Application No: EP/133/21/HH
Site Address: 11 Worthing Road East Preston BN16 1AT
Description of works: Rear roof dormer extension including the installation of 2 x side windows and 3 x front velux rooflights

Thank you for your internet representation made on 16th November 2021 which has been recorded as an objection with the comments as follows:

FRONT (s) ELEVATION 1:100 @ A3
 0 1 2 3 4 5m
 metres

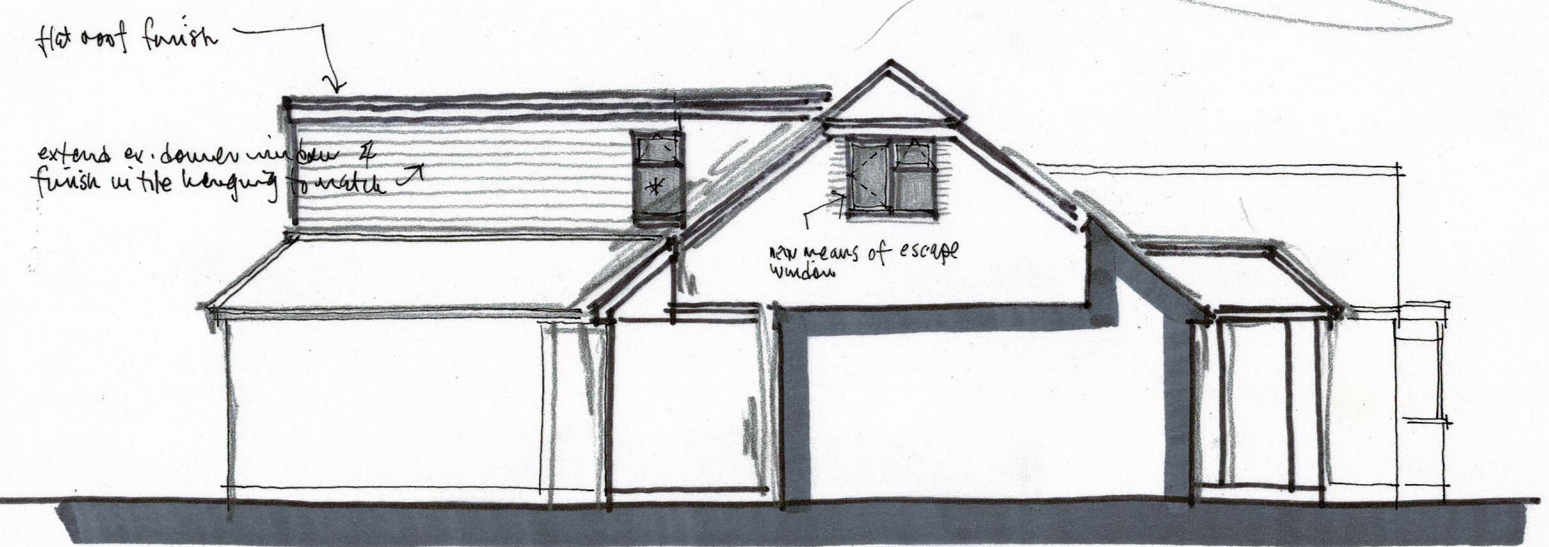
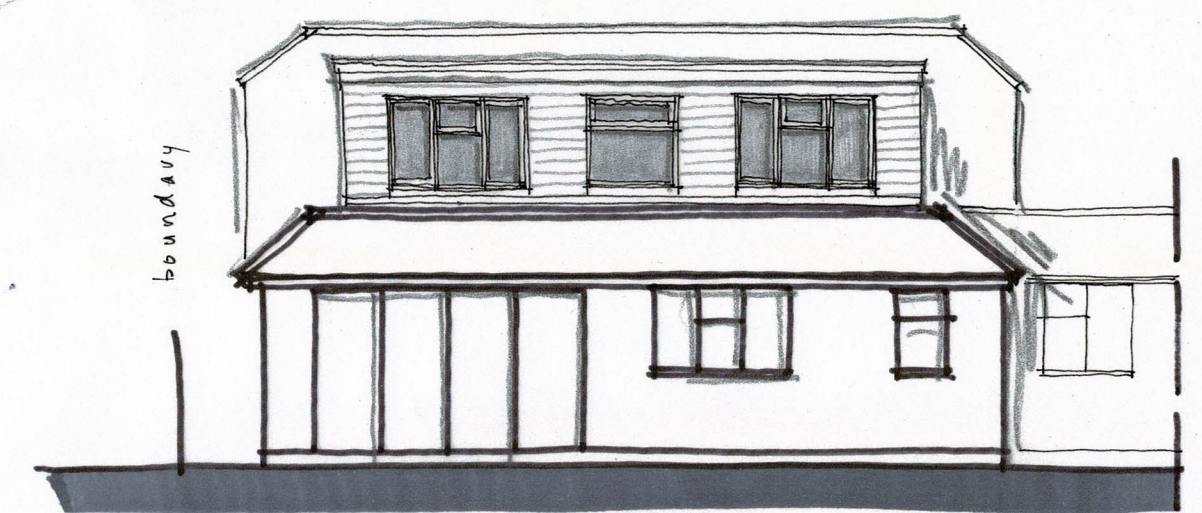
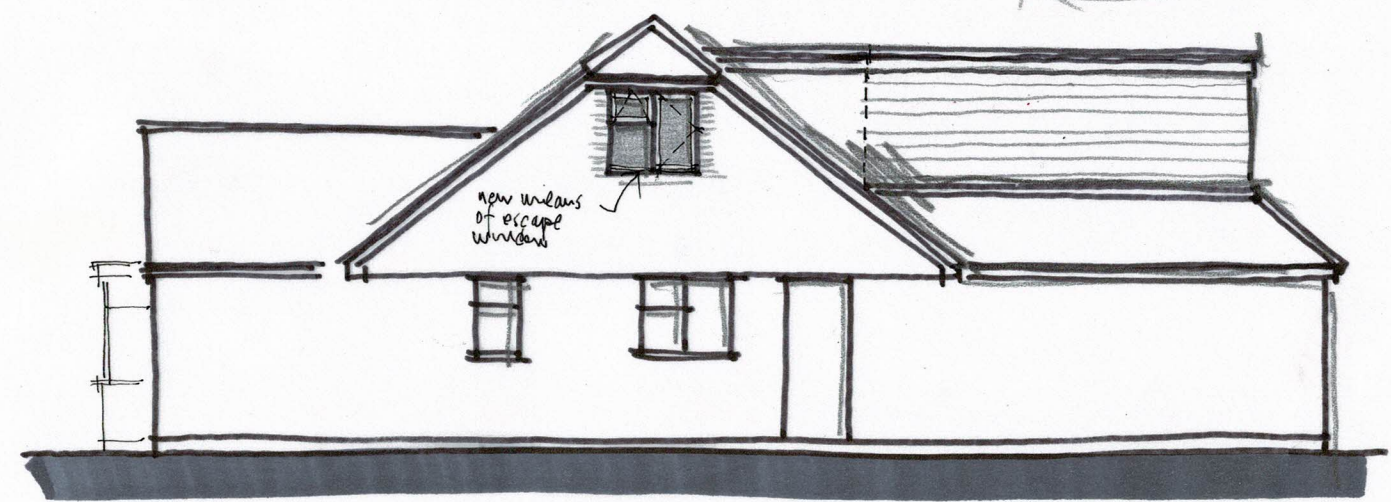
I write as Chairman of the East Preston and Kingston Preservation Society. The proposal is an overdevelopment of an already much altered small semi-detached bungalow. The appearance of three roof lights on the street-facing elevation would not fit in with neighbouring buildings. The cumbersome extension to the first floor would be visible from the street and would not appear integrated with or subservient to the original structure and would further compromise the symmetry of the attached bungalow to the west. The proposed side windows would overlook neighbouring properties. Even if these were to be conditioned as obscure glazed, as MOE they would have to be fully opening, again to the detriment of the amenity of neighbouring properties. The Society therefore asks that this application be refused.
